**Ref No:** F2020/00664

Application No: SSD-10822510

**Re: Randwick City Council submission on the State Significant Development SSD-10822510 – UNSW Health Translation Hub (SSD-10822510)**

drawing
Shadow Analysis

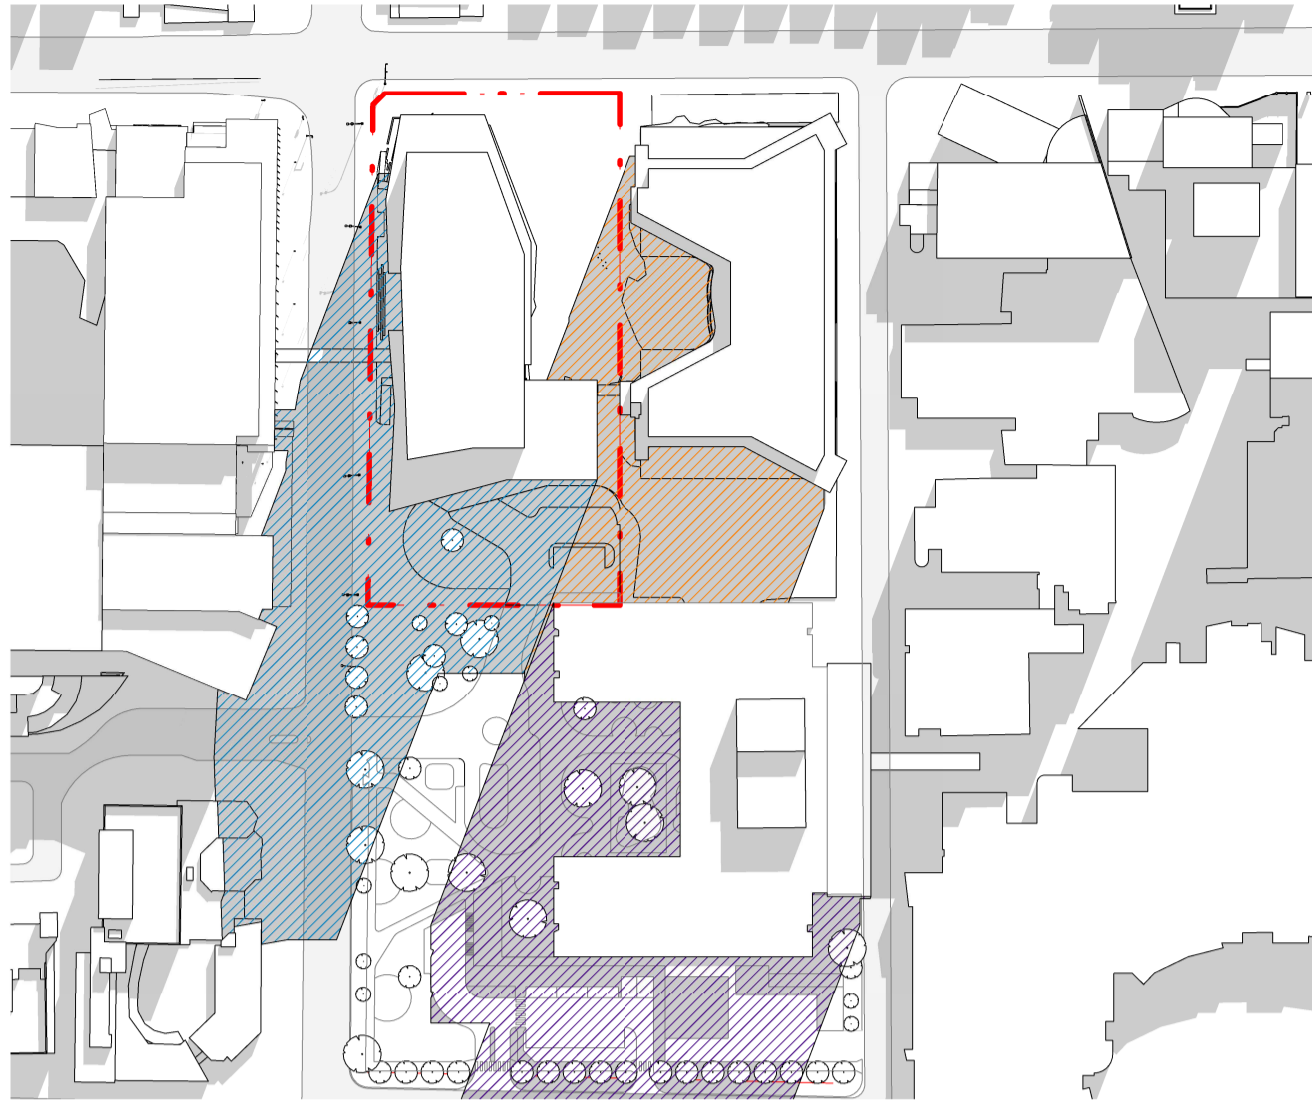
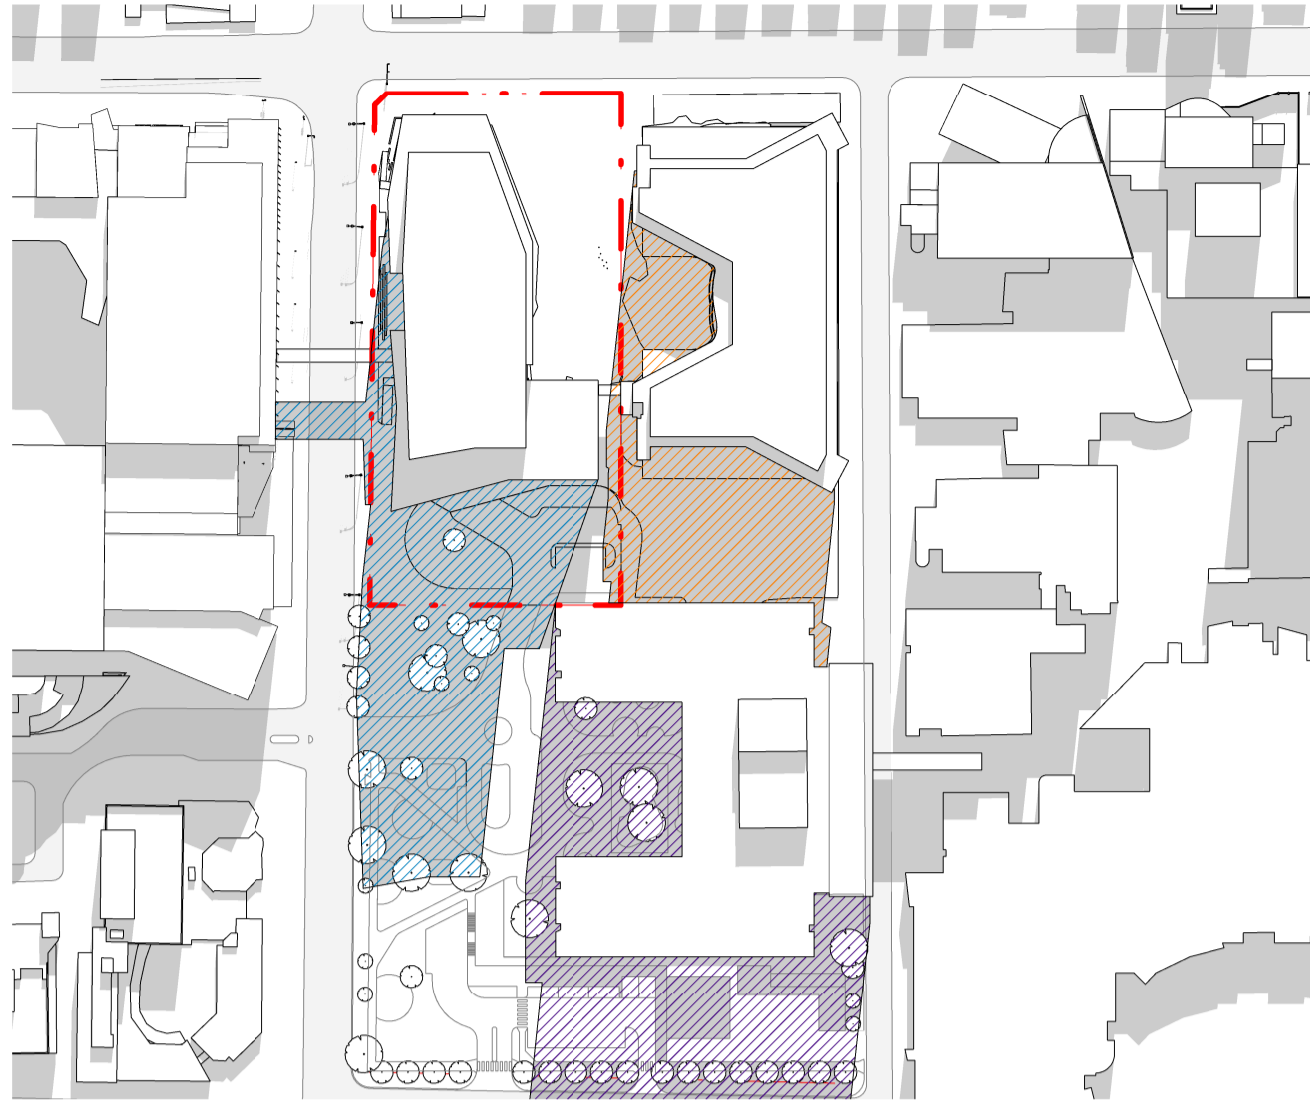
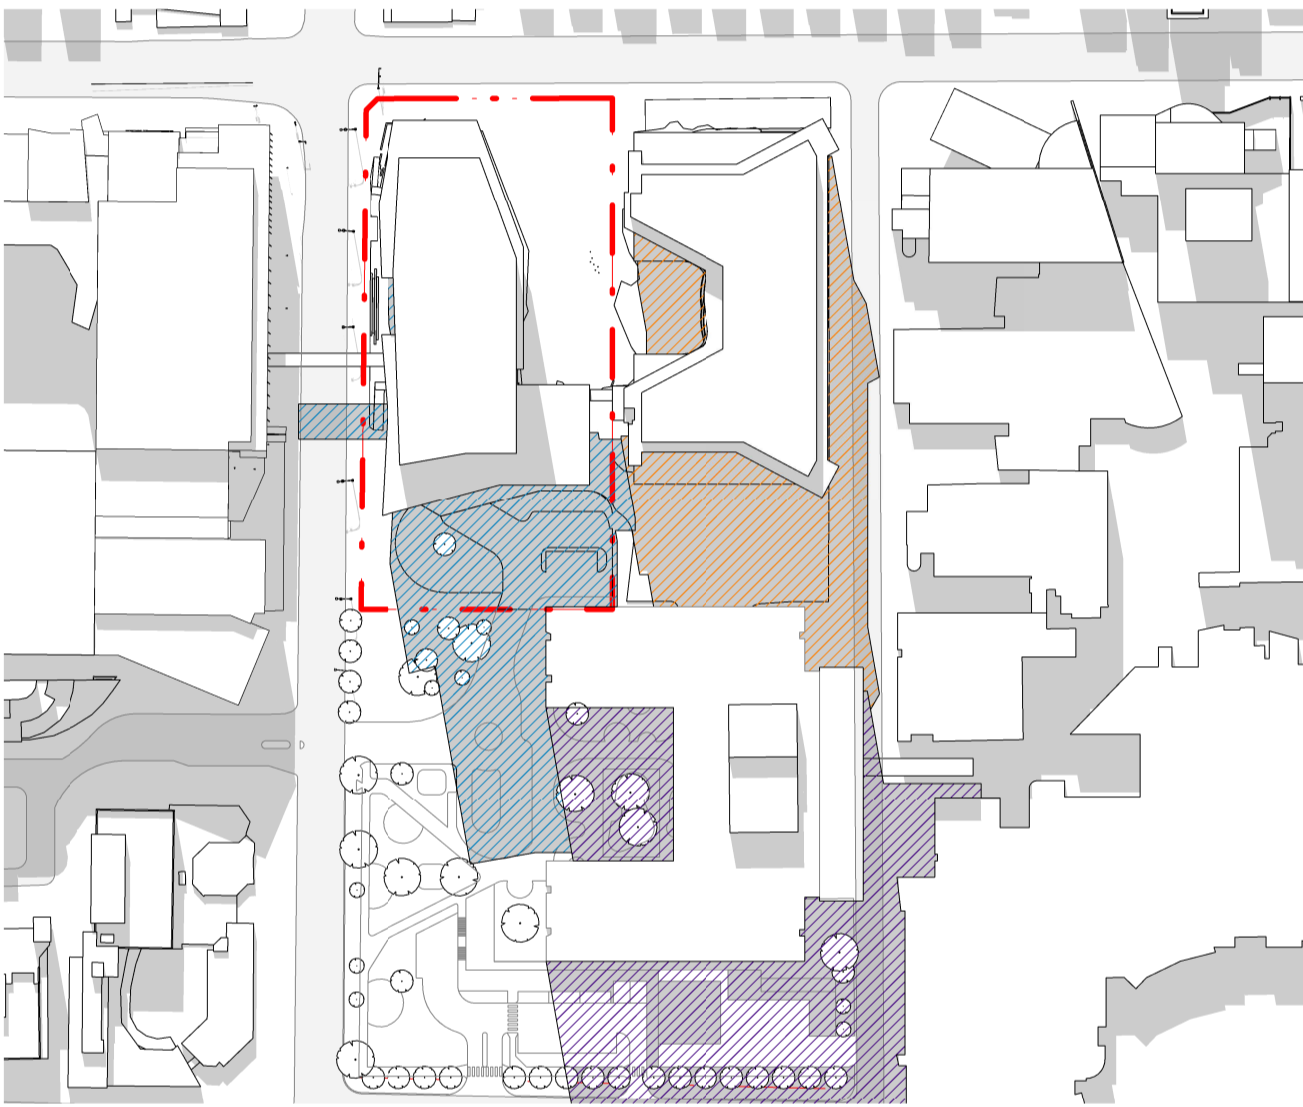
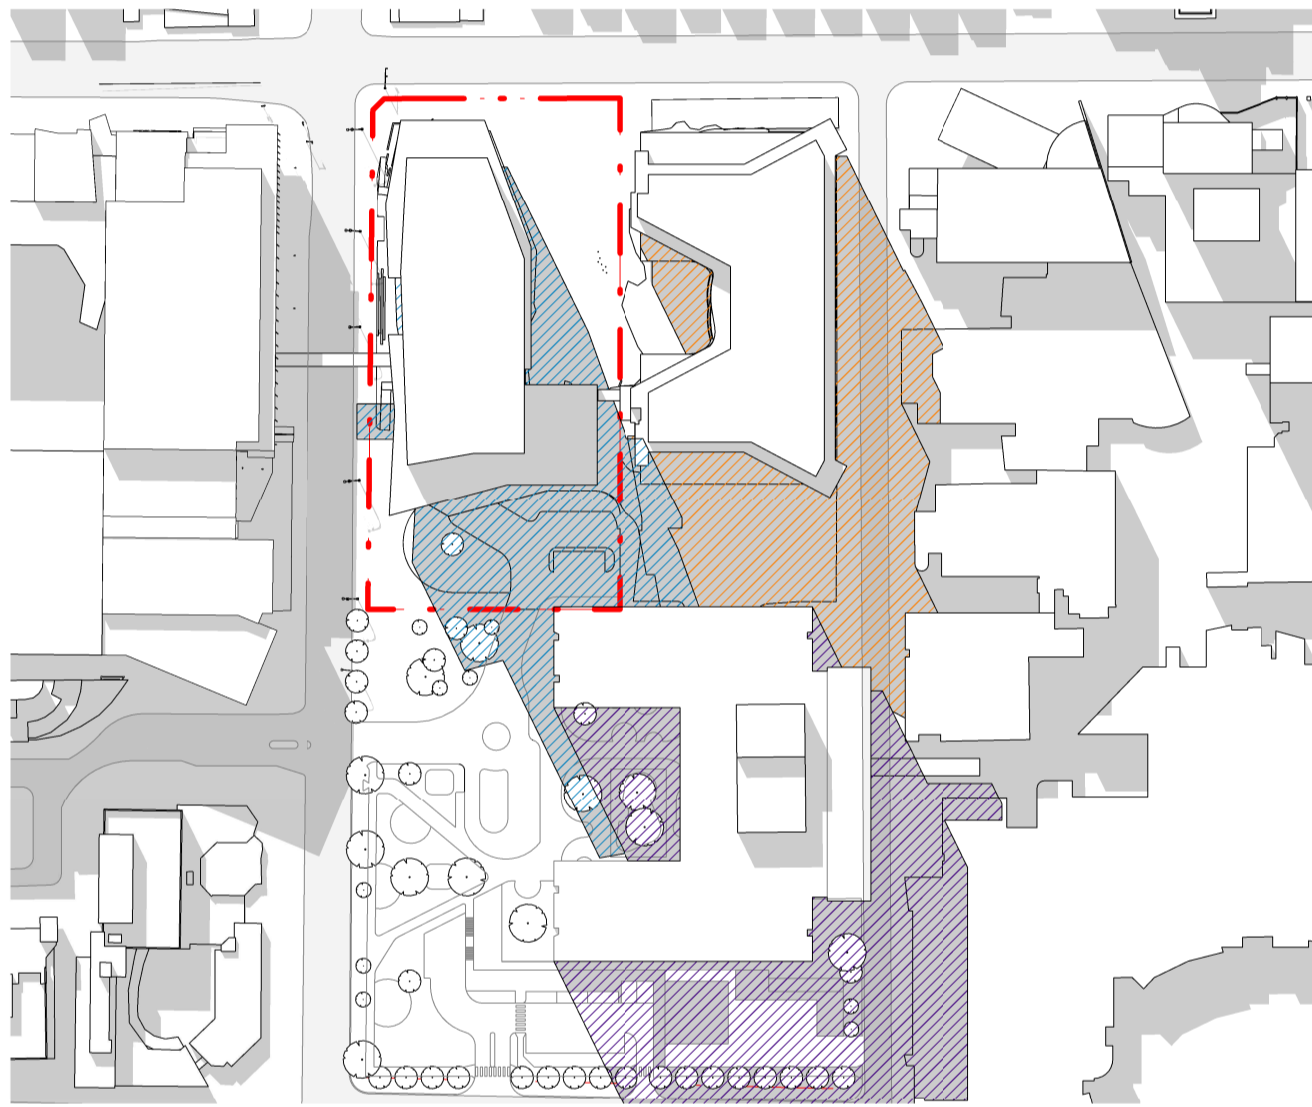
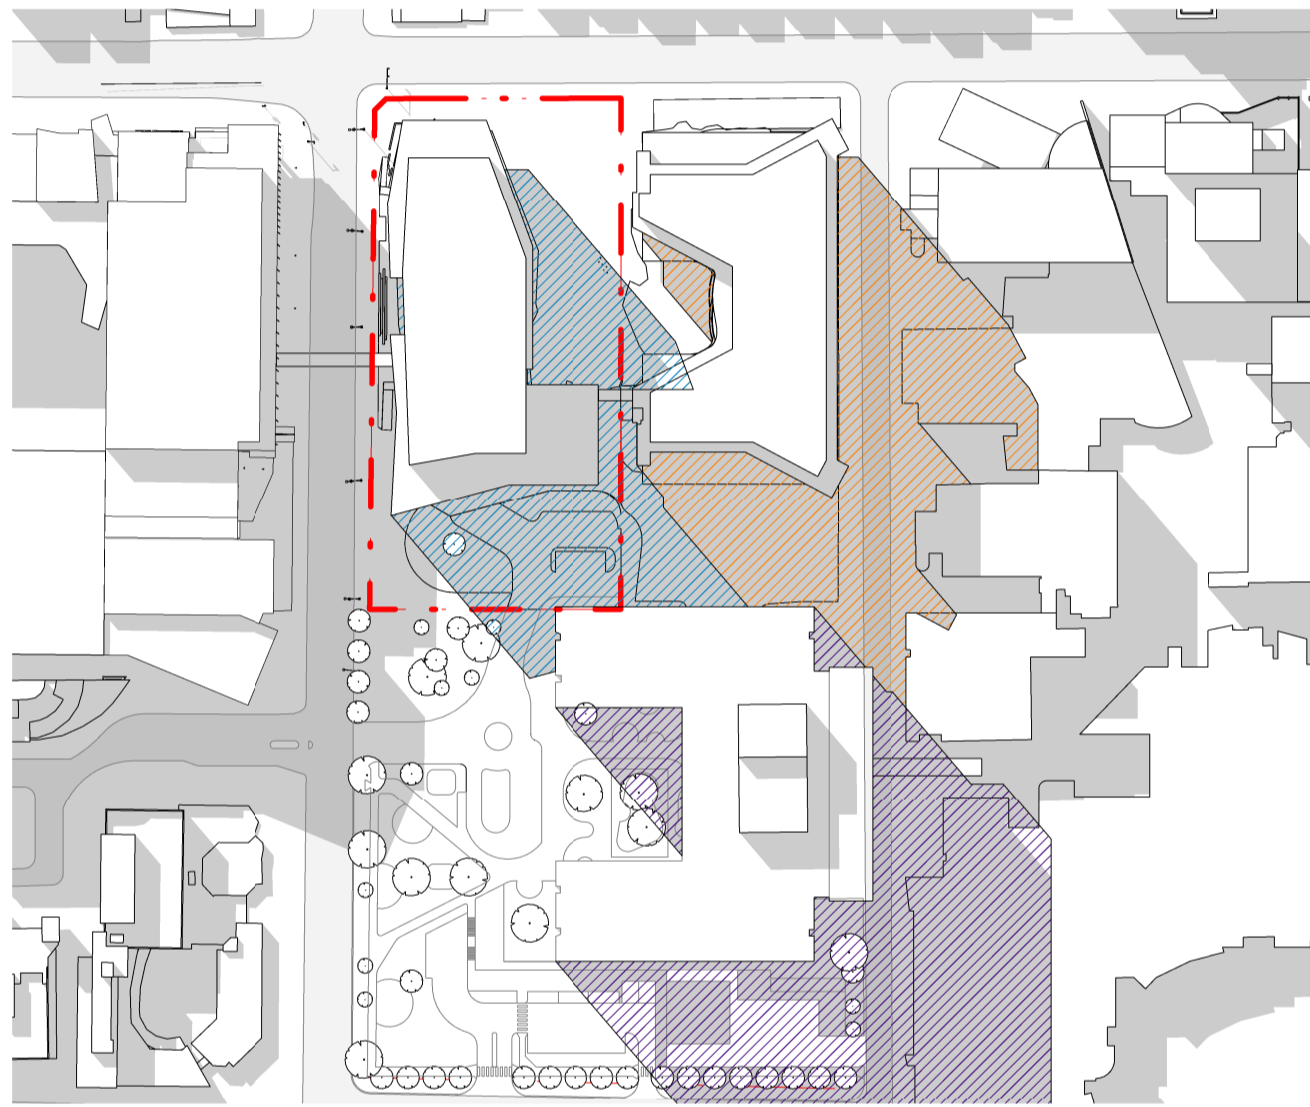
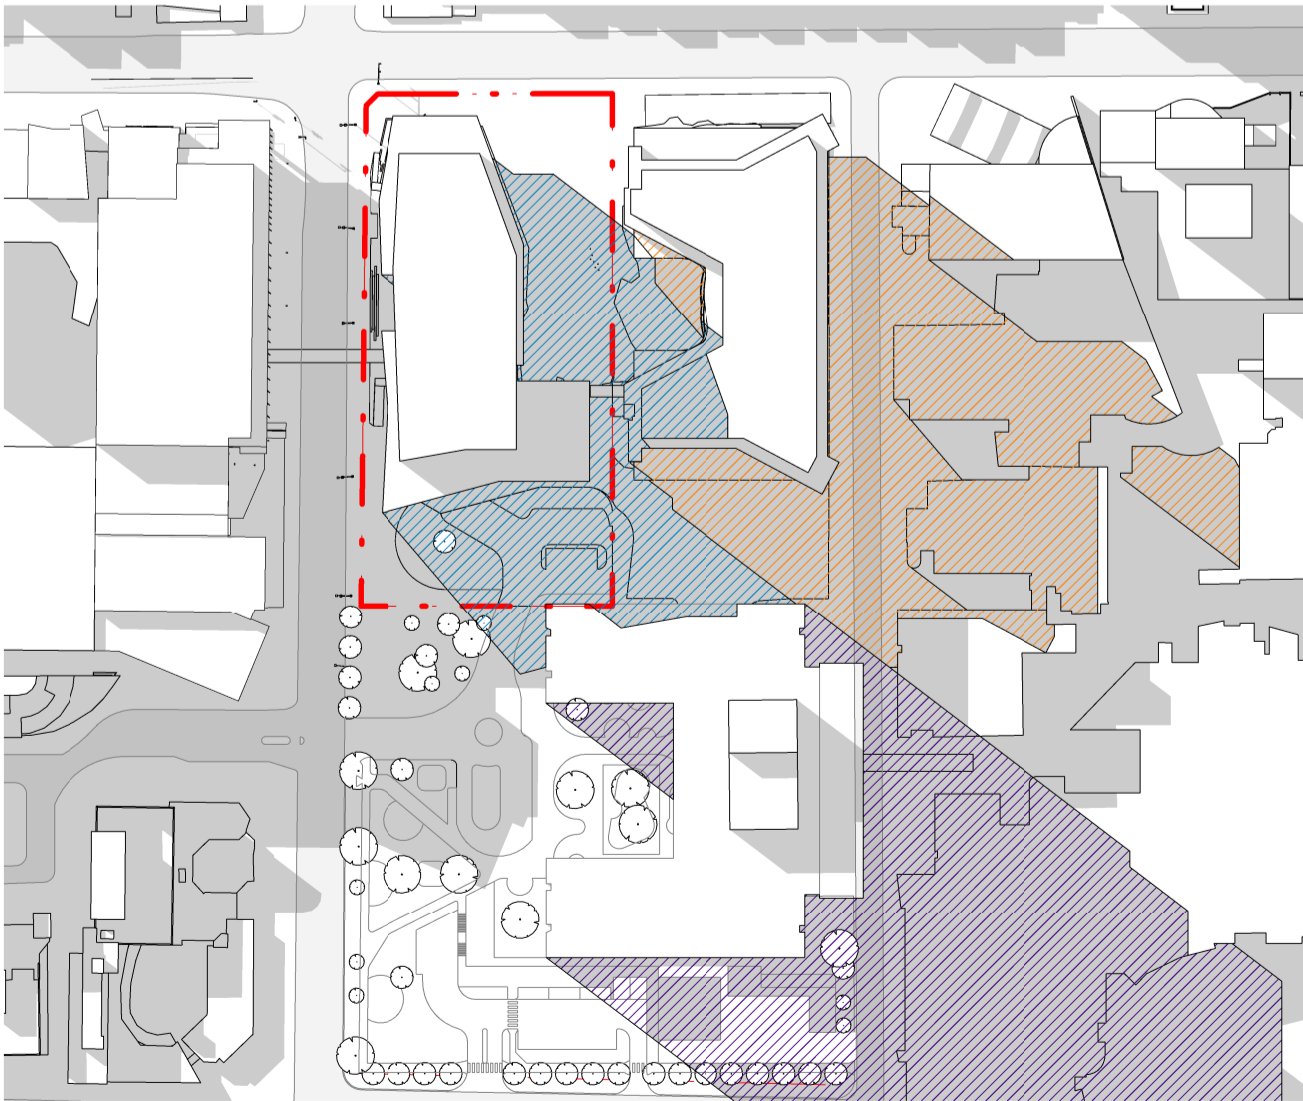
6. The Integrated Acute Services Building (IASB) forecourt and main hospital vehicular drop-off/pick-up has the potential to provide an important new green space along Botany Street for the enjoyment of Randwick Hospital, the UNSW campuses, and the broader Randwick community. It will be important to provide a quality landscaped experience that is not unduly overshadowed in the winter months by the upper levels of the proposed UNSW HTH building to the north.
7. It appears that the current southern leg of the UNSW HTH building will overshadow the Children's Hospital emergency vehicular drop off loop and pedestrian waiting area, as currently configured, for most of winter months.
8. The shadow diagrams provided are limited, addressing only the early morning, midday and late afternoon. Hourly shadow diagrams at the 21 June should be provided to assess solar access and amenity.
